**From:** Bloomer, David <David.Bloomer@lancashire.gov.uk>  
**Sent:** 25 June 2018 11:42  
**To:** Robert Major  
**Cc:** LHS Customer Service; planning  
**Subject:** app3/2017/1020 Unit A to C Upbrooks, Clitheroe

The proposal raises no highway concerns but the construction of the new access will require works within the highway which will need to be undertaken under a S278 agreement. As part of the works I will also require a short extension of the footway up to the proposed vehicle access gate, currently this is grass verge. Subject to the following conditions being attached to any permission that may be granted, I would raise no objection to the proposal on highway grounds

CLUTTERIDGE LIGHT
ENGINEERING CO LTD
UPPERCROFT INDUSTRIAL ESTATE
PROPOSED NEW BUILDING
PROPOSED SITE PLAN
PHASE 2/200 OCTOBER 2017
1:100 at A1
10/3/16 ucl

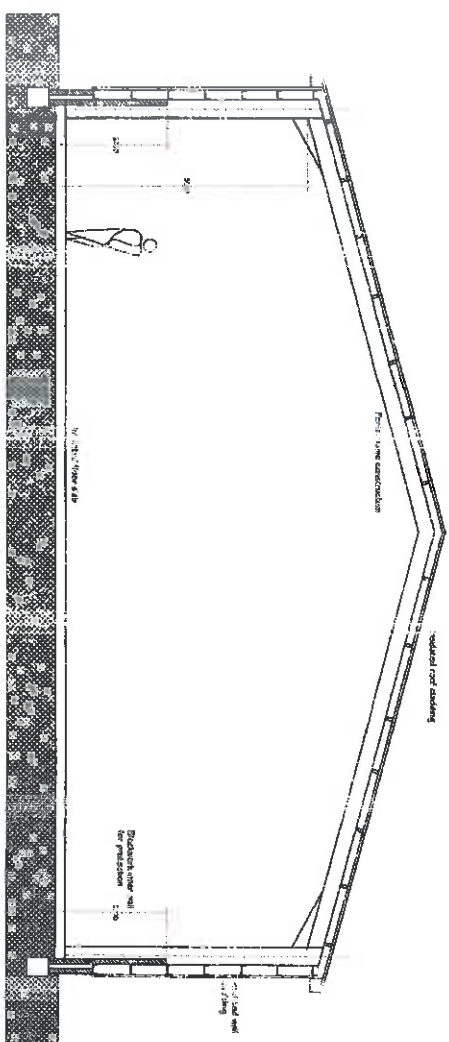
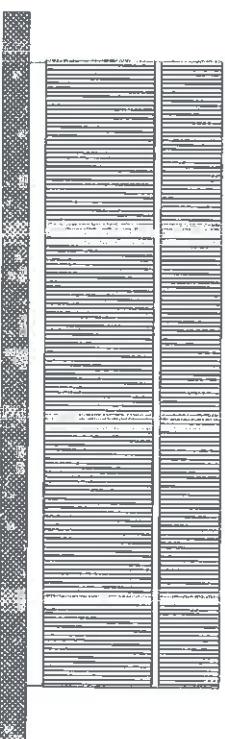
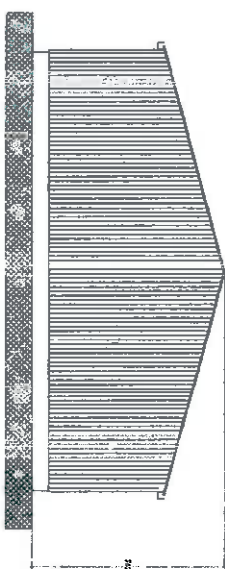
1 Before the access is used for vehicular purposes, any gateposts erected at the access shall be positioned 5m behind the nearside edge of the footway and visibility splay fences or walls shall be erected from the gateposts to the existing highway boundary, such splays shall be 45° to the centre line of the access. The gates shall open away from the highway. Should the access remain un-gated 45° splays shall be provided between the highway boundary and points on either side of the drive measured 5m back from the nearside edge of the carriageway. Reason: To permit vehicles to pull clear of the carriageway when entering the site and to assist visibility

2 The layout of the development shall include provisions to enable vehicles to enter and leave the highway in forward gear and such provisions shall be laid out in accordance with the approved plan and the vehicular turning space shall be laid out and be available for use before the development is brought into use and maintained thereafter. Reason: Vehicles reversing to and from the highway are a hazard to other road users

3 The car park shall be surfaced or paved in accordance with a scheme to be approved by the Local Planning Authority and the car parking spaces and manoeuvring areas marked out in accordance with the approved plan, before the use of the premises hereby permitted becomes operative. Reason: To allow for the effective use of the parking areas
